**KIRKLEES METROPOLITAN COUNCIL  
INVESTMENT & REGENERATION SERVICE**

**DELEGATED DECISION TO DETERMINE PLANNING APPLICATIONS**

| Reference No:         | <b>2022/62/93963/E</b>                          |
| Description:          | Erection of dormer windows to front and rear    |

PHASE	SCALE	SHEET NO.	PROJ.NO.
Planning Application	Varies @ A3	AR-01	C22076

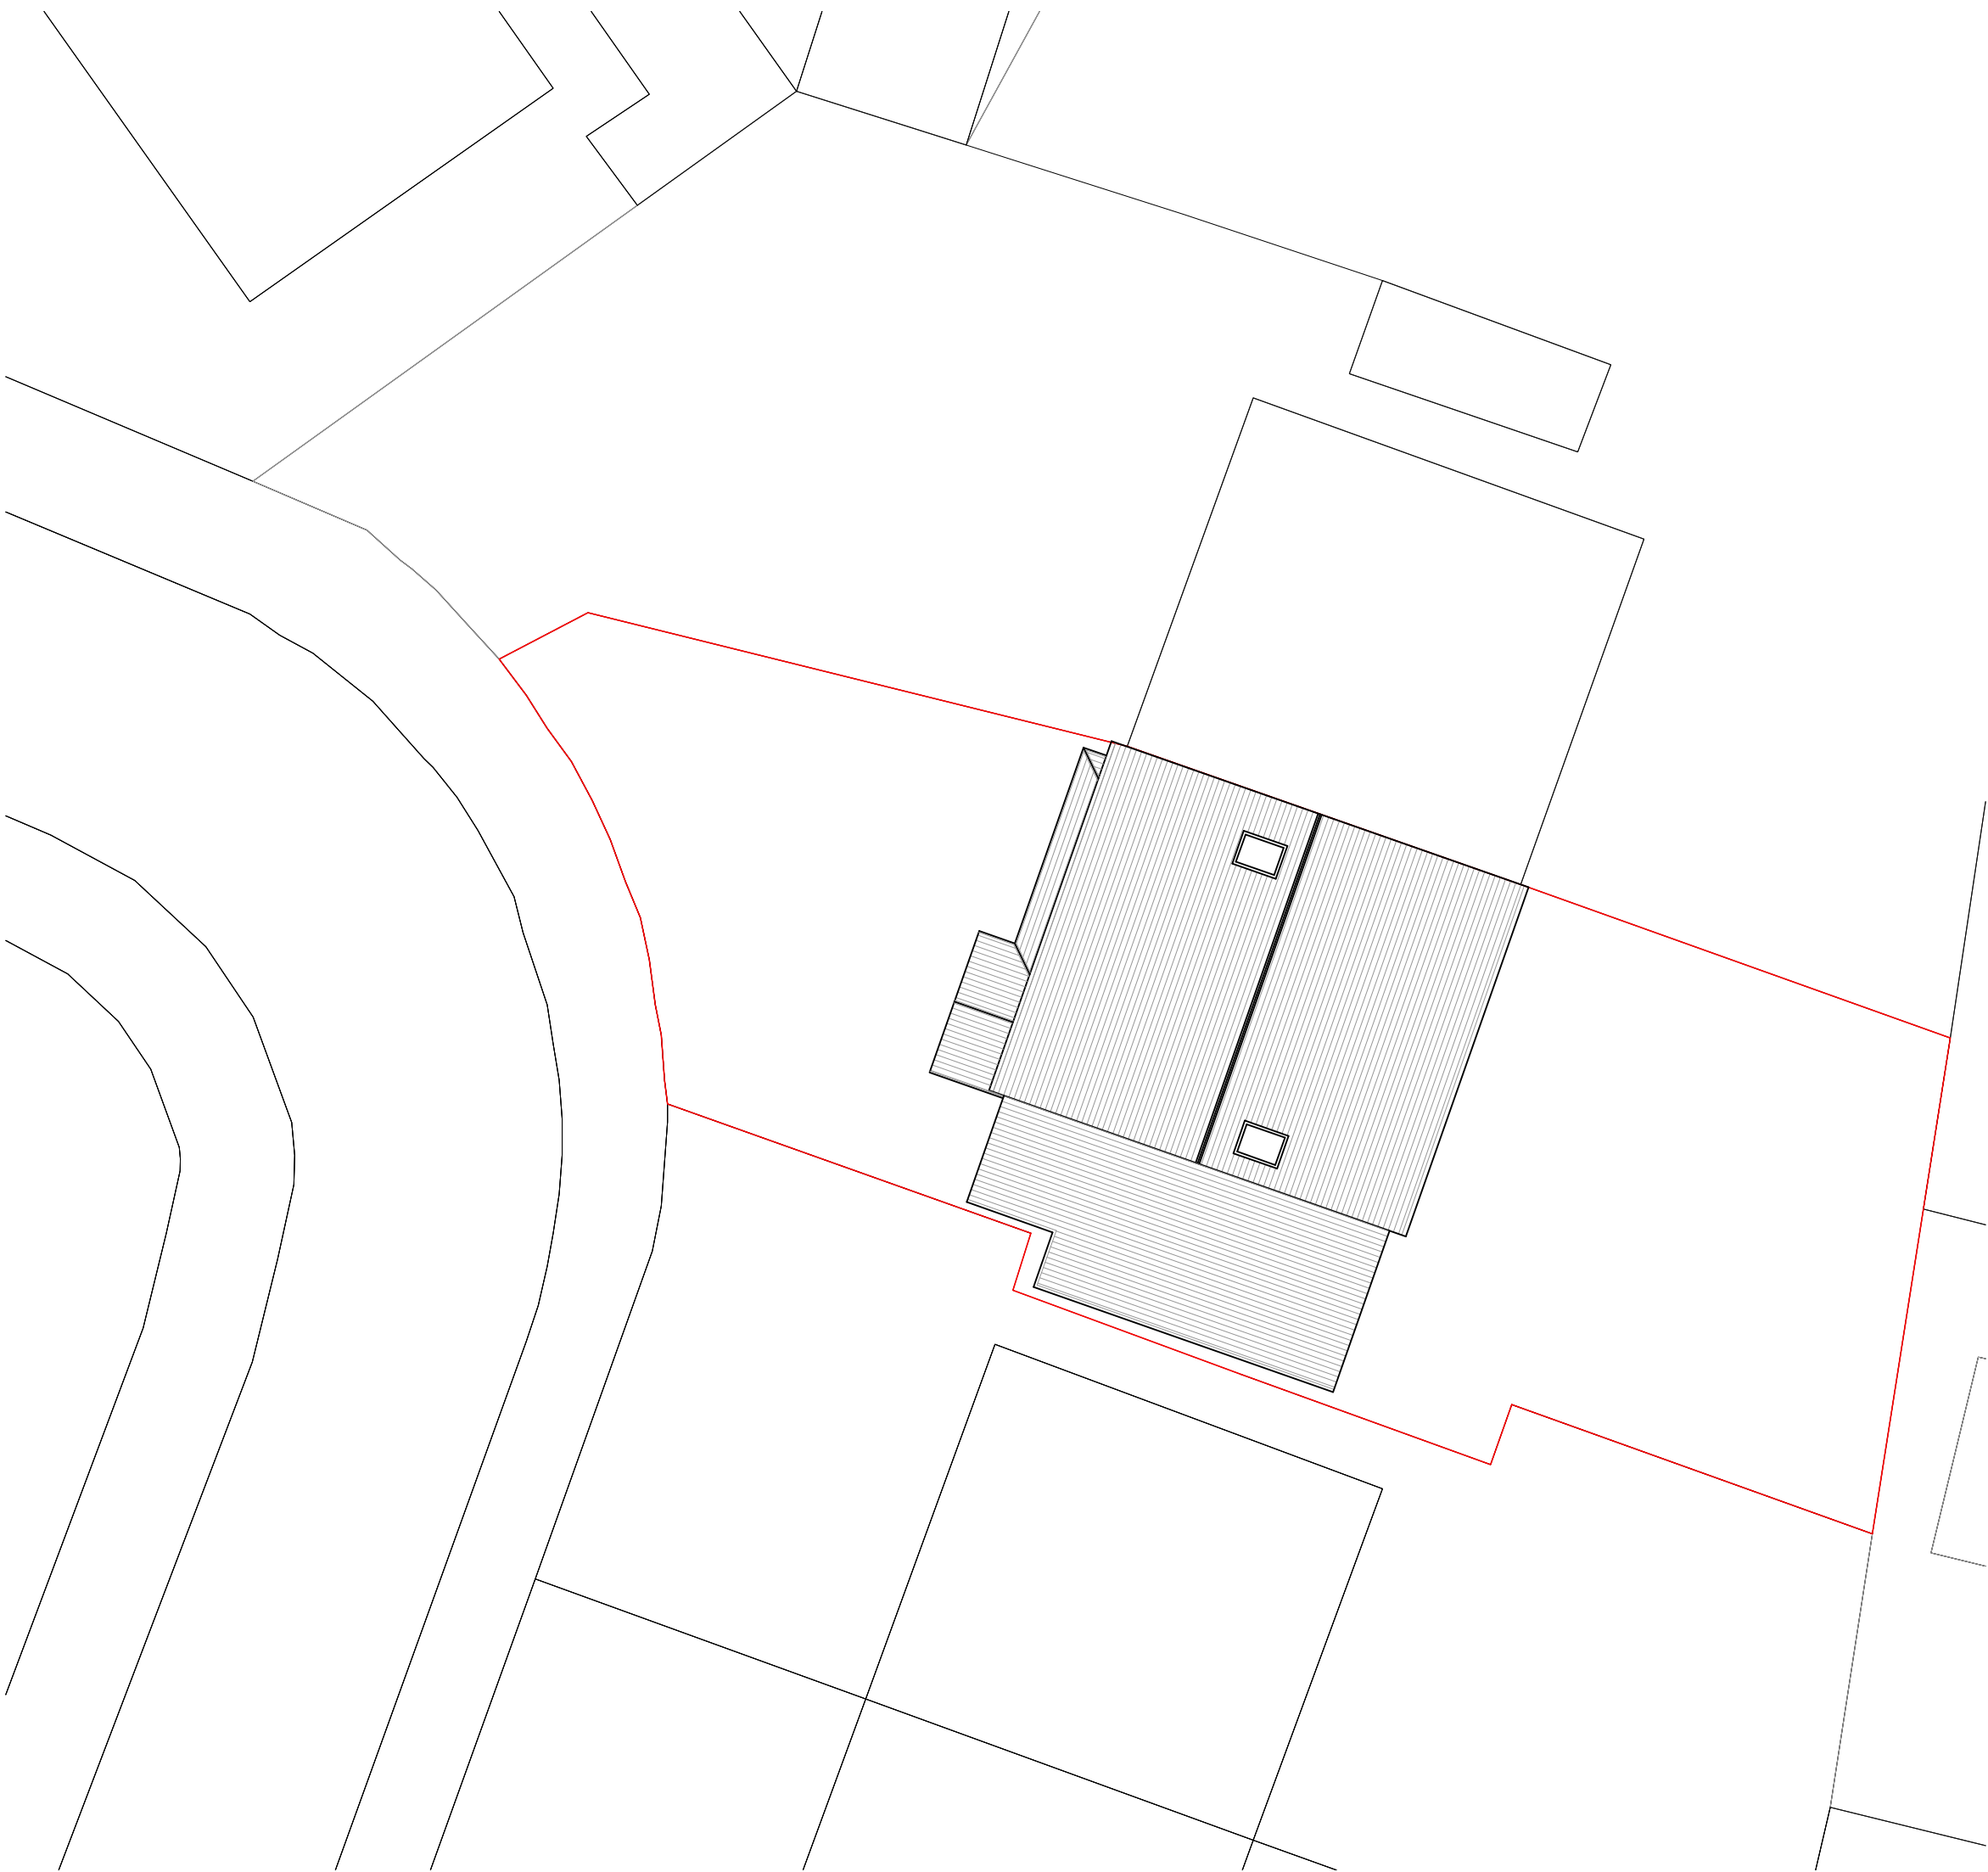
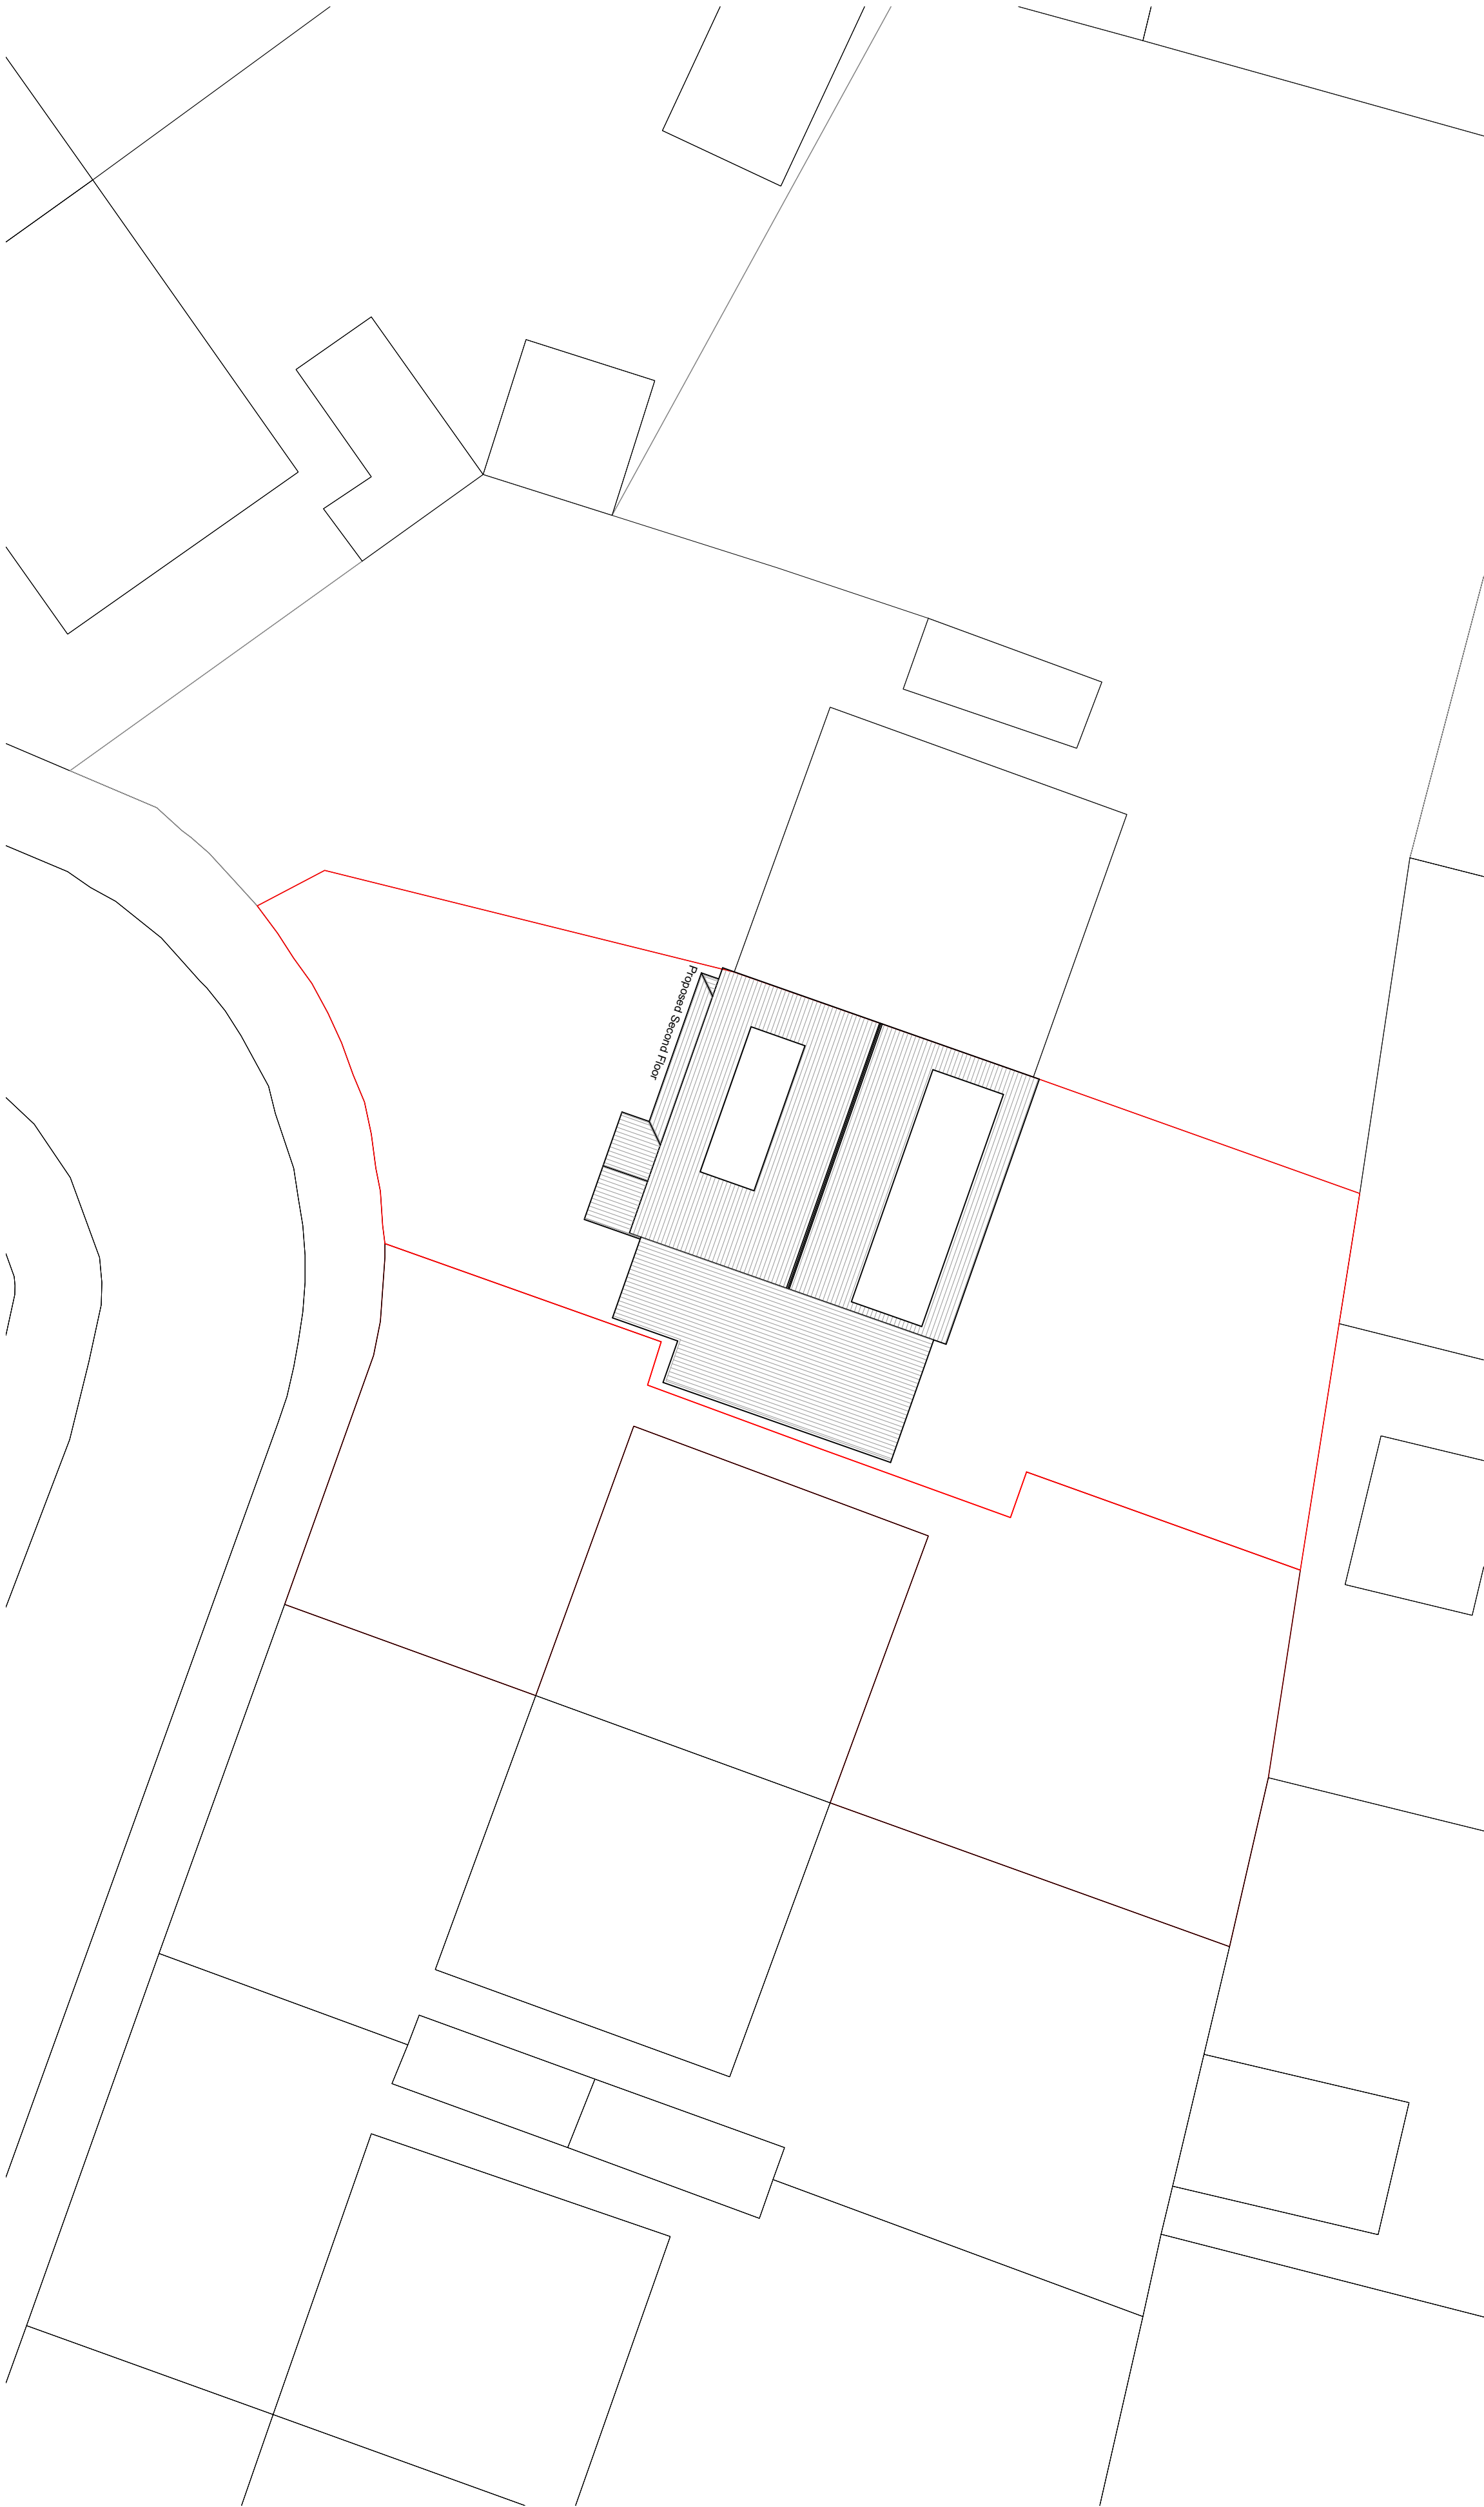
The plans confirm that sufficient outdoor amenity space of a functional layout would be retained at the site. On this basis, the proposed works would ensure an acceptable standard of amenity for existing and future occupants.

The proposal would create one additional bedroom, which would intensify the domestic use at the dwelling. However, it is noted that off road parking would be retained for two vehicles which is considered to represent a sufficient provision for a three bedroomed dwellinghouse. Therefore, the proposed development is considered acceptable in accordance with Policies LP21 and LP22 of the KLP, Chapter 9 of the NPPF, Principles 15 and 16 of the Kirklees House Extensions and Alterations SPD and the Highways Design Guide SPD.
